Application no: **3/2024/0128**

Address: **Cunliffe House Farm Longsight Road Langho BB6 8AD**

Proposal: **Prior notification for change of use of agricultural building to a use within Class B8 (Storage and Distribution) under class R for the storage of ATV vehicles in connection with a wider dealership.**

The Local Highway Authority have viewed the plans and highway related documents and have the following comments to make:

Class R - Change of Use	
Cunliffe House Farm Longsight Road Langho	
CLIENT:	Mrs C Barker
DATE:	
SCALE:	1:500 & 1:1250 @ A1
DWG No:	
L.A:	
AMENDMENTS:	DATE: 16/02/2024

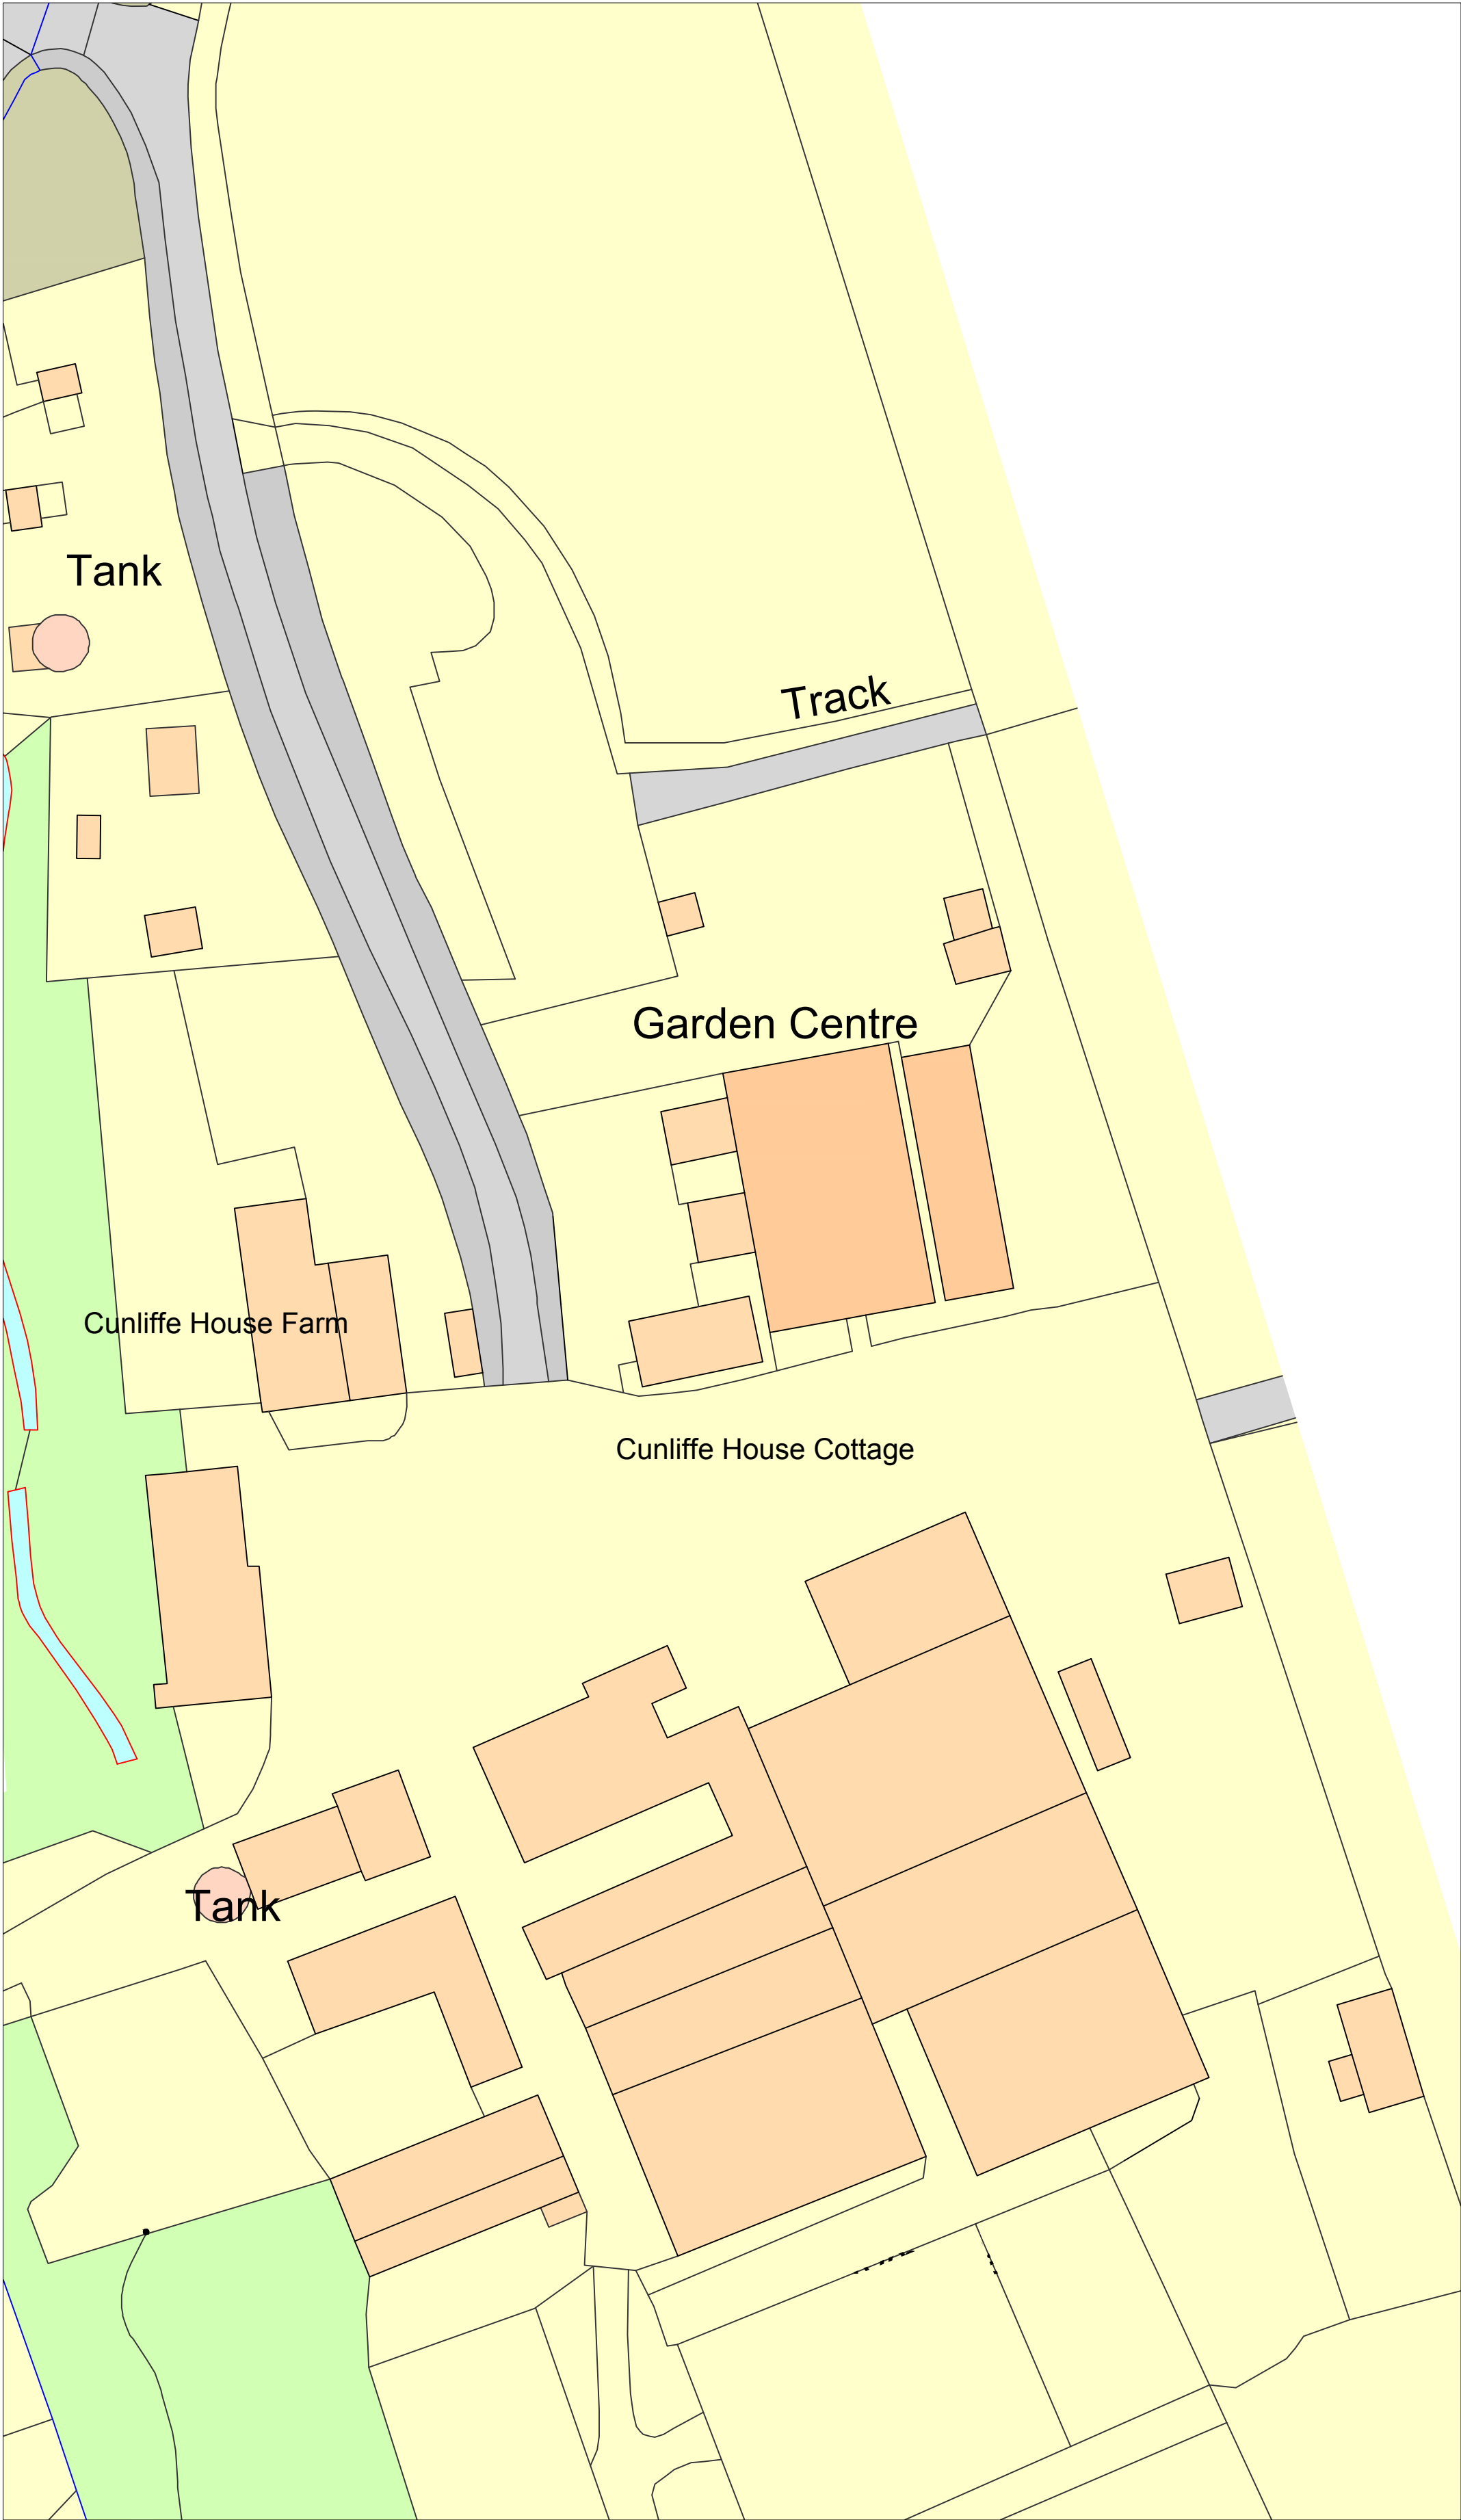
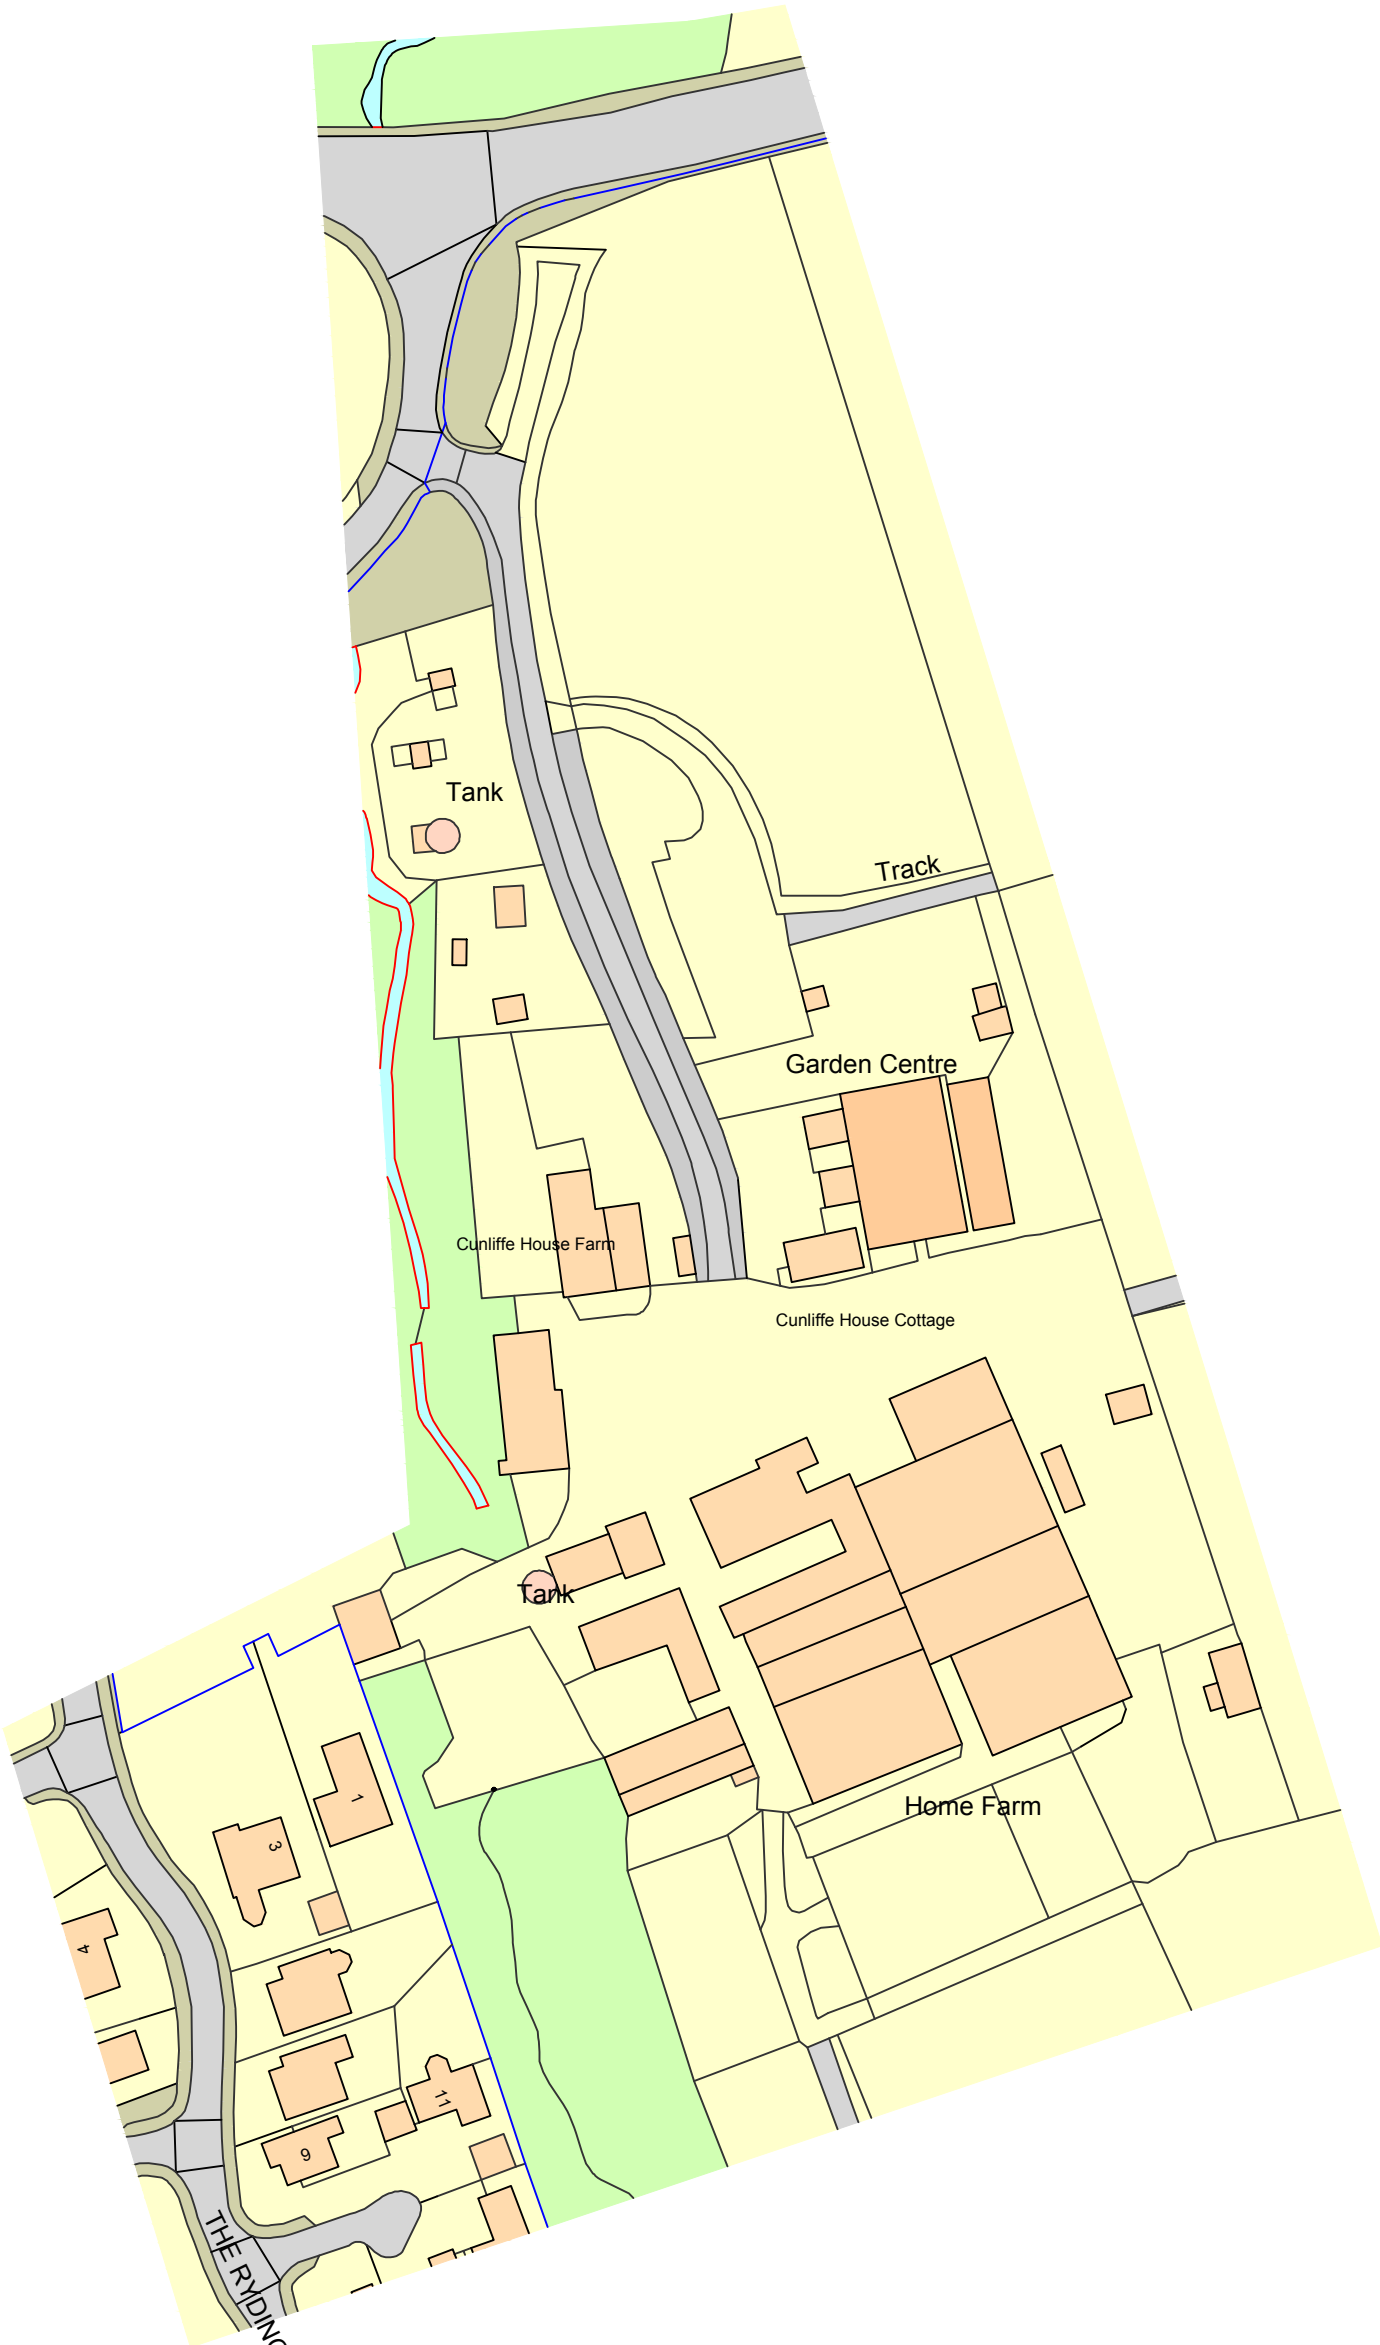
The site will continue to utilise an existing unadopted access track located off The Rydings, which is an unclassified road subject to a 30mph speed limit. The existing access track currently serves the farm and other commercial units including a garden centre.

Before the LHA can comment on the suitability of the access track and the site for the proposed use, the LHA require further information in the guise of an Operation Statement to be submitted. The LHA require information regarding the following:

- Where is the ATV dealership located?
- Will any sales occur at the site?
- The frequency of deliveries to and from the site.
- The types of vehicles which will service the site.

Should the site be open to the public, the LHA will require suitable parking facilities to be provided and should the frequency of deliveries be high, a suitable turning area for the largest servicing vehicle should be provided.
